M3 Junction 9 Improvement

Scheme Number: TR010055

7.12.7 Statement of Common Ground with Cycle Winchester

31 July 2023

**DRAWING TITLE**  
 FIGURE 2.5 - THE SCHEME: TEMPORARY TRAFFIC DIVERSION ROUTES  
 APFP REGULATIONS 5(2)(a)  
 SHEET 2 OF 12  
 DOCUMENT REFERENCE 6.2

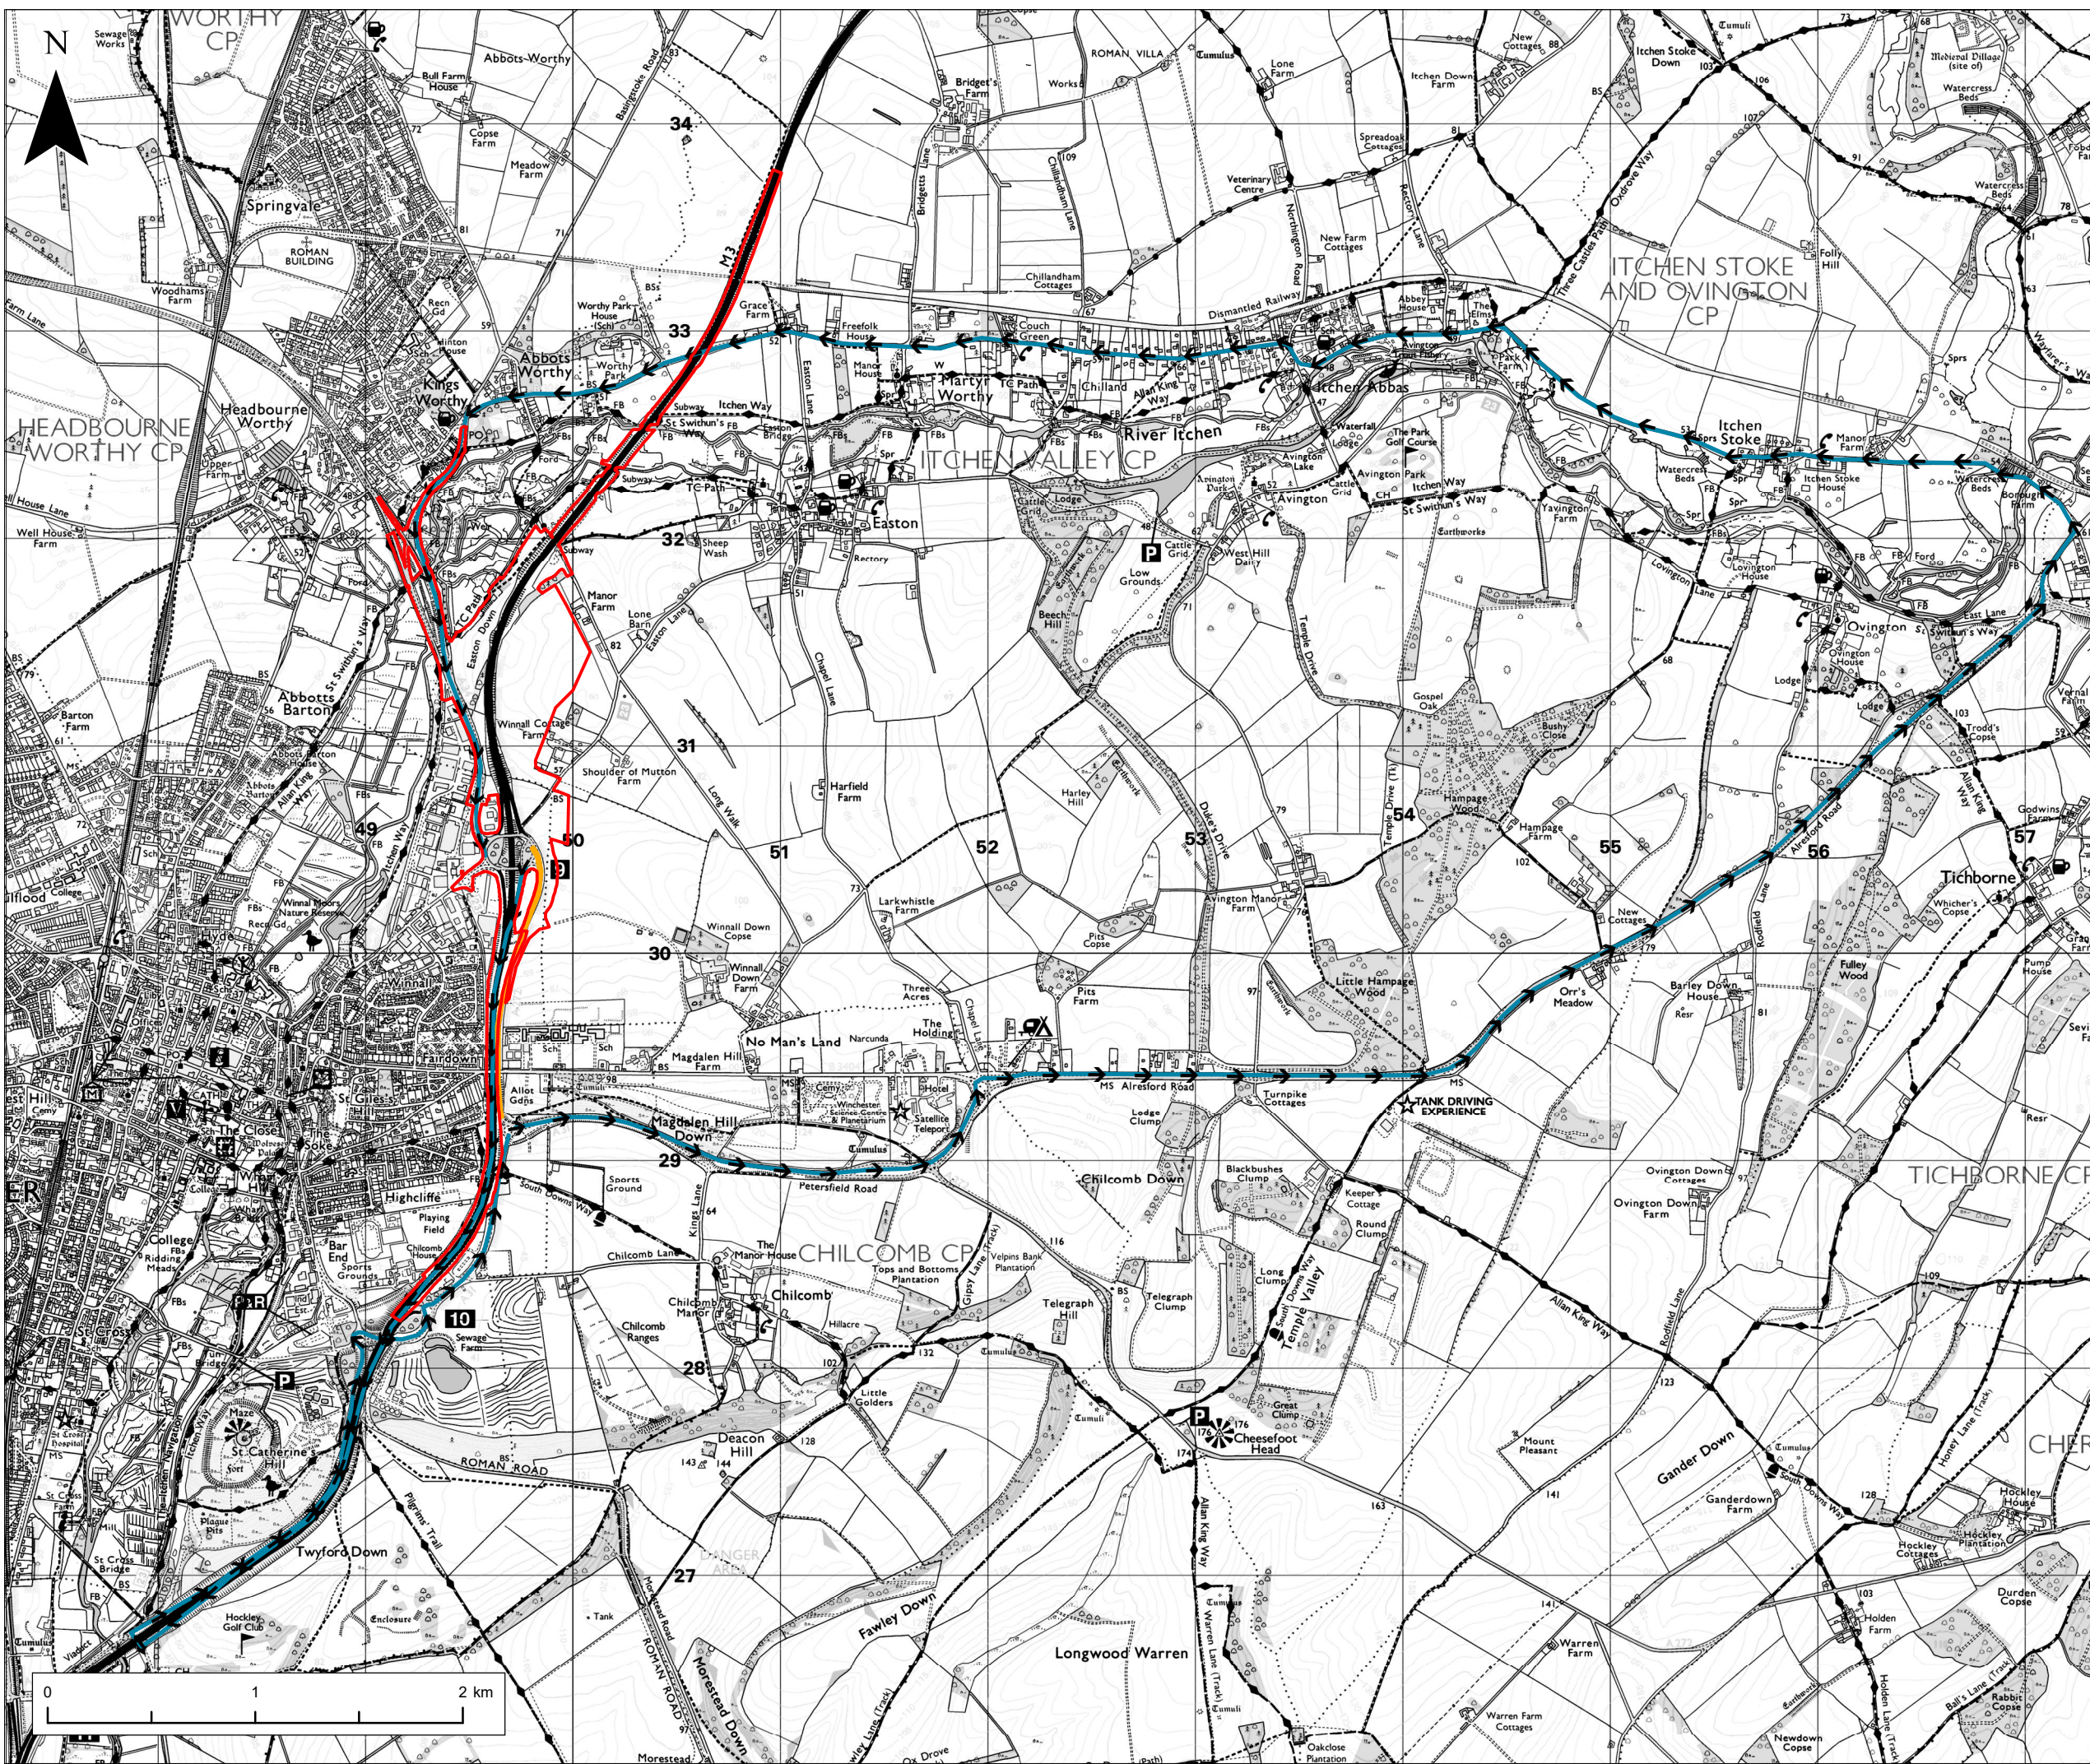
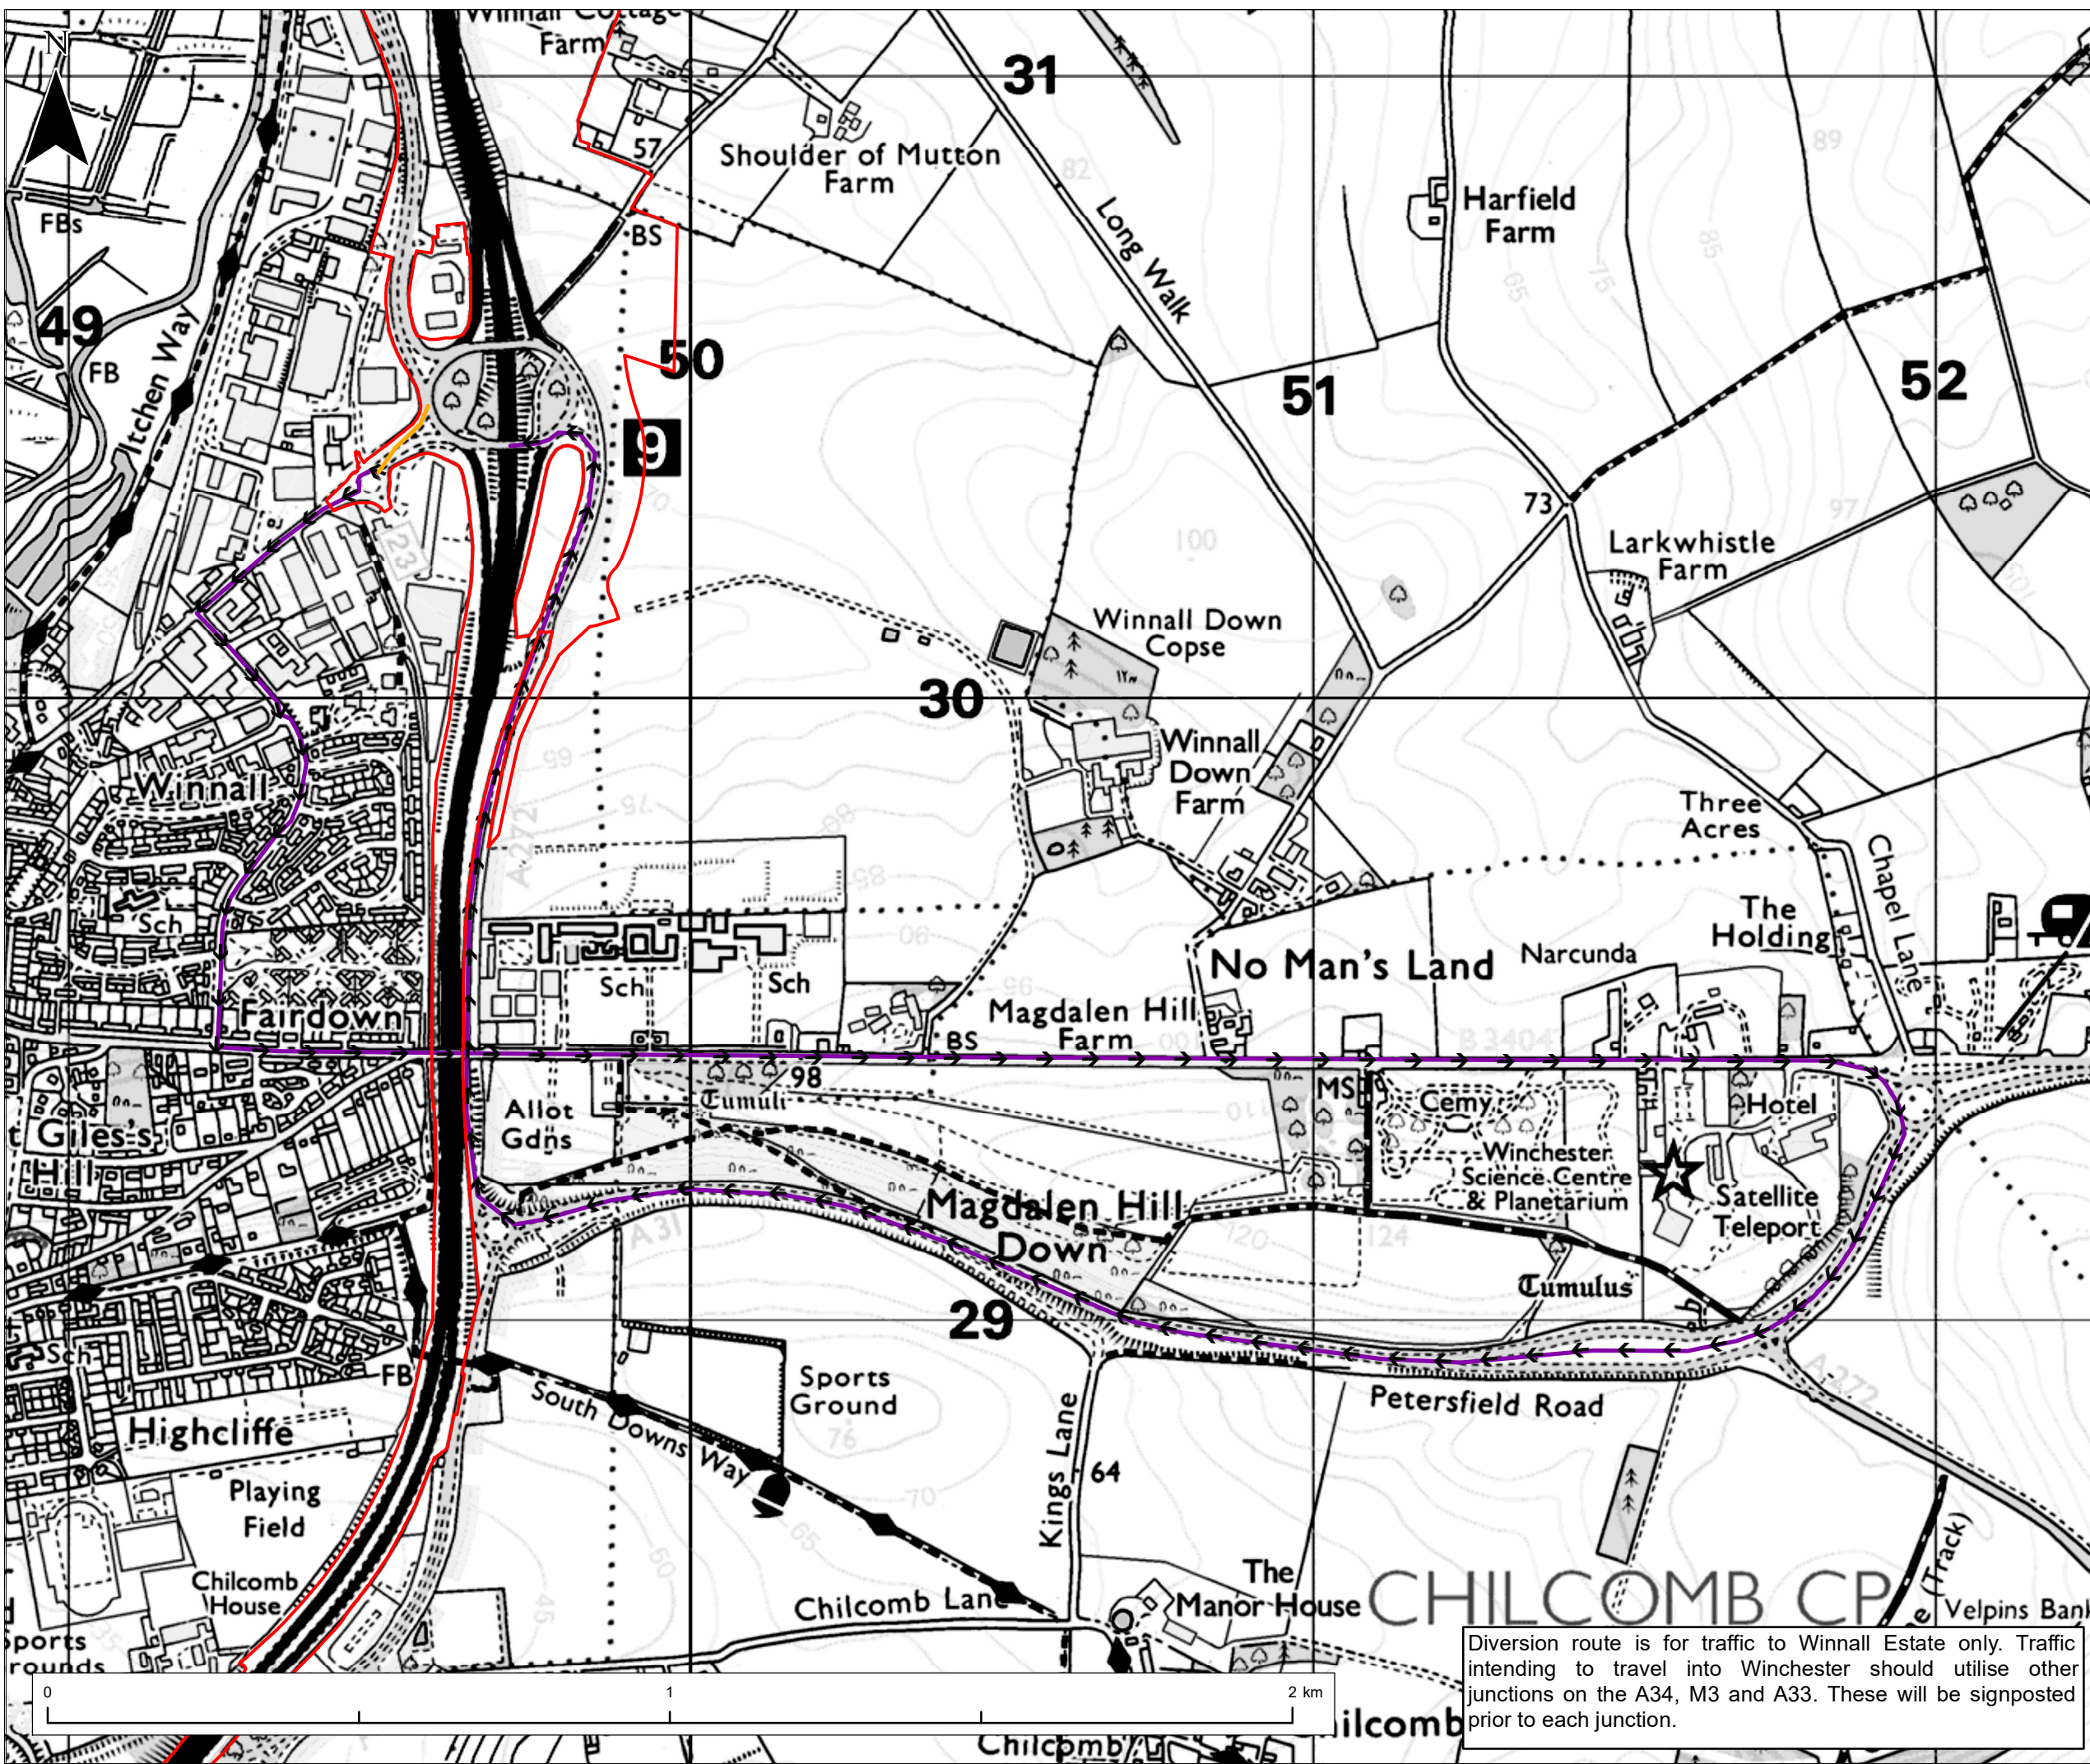
5.2	Diversion routes Impact of traffic diversion on cyclists	Outline Traffic Management Plan (7.8, Rev 1), Figure 2.5 of Chapter 2 (The Scheme and its Surroundings – Figures (Part 3 of 4)) of the ES (6.2, APP-063)	<p>Cycle Winchester has the impression that the project team has not yet considered the impact that traffic diversions during construction will have on cyclists. Examples of areas where the diverted traffic might have an impact on cycling include many of the major routes in and out of Winchester, as a Junction 9 closure or complete M3 closure would force more traffic onto these roads. Some examples:</p> <ul style="list-style-type: none"> ▪ B3047 Worthy Road/Martyr Worthy Road ▪ B3335 St Cross Rd and Twyford Road ▪ B3420 Andover Road ▪ B3330 Bar End Road ▪ Minor roads, especially in the upper Itchen valley east of the junction <p>Again, we would like to see a clear consultation process that will ensure that consultation happens, that the effects on non-motorised road users are accounted for, and appropriate measures are taken.</p>	<p>Diversion routes via the B3047, the B3420 Andover Road and road east of the junction (A31) will be implemented at various stages of the Scheme. The works are planned to be undertaken during overnight off-peak closures (when there is less traffic on the network) and several extended weekend closures.</p> <p>The B3335 St Cross and Twyford Road and B3330 Bar End Road have been referenced as secondary diversion routes and should only be used by non-motorway traffic, or for those accessing the residential area at Bar-End.</p> <p>There are mitigation measures for rat-running and this will be monitored throughout construction of the Scheme.</p>	Agreed	6 July 2023
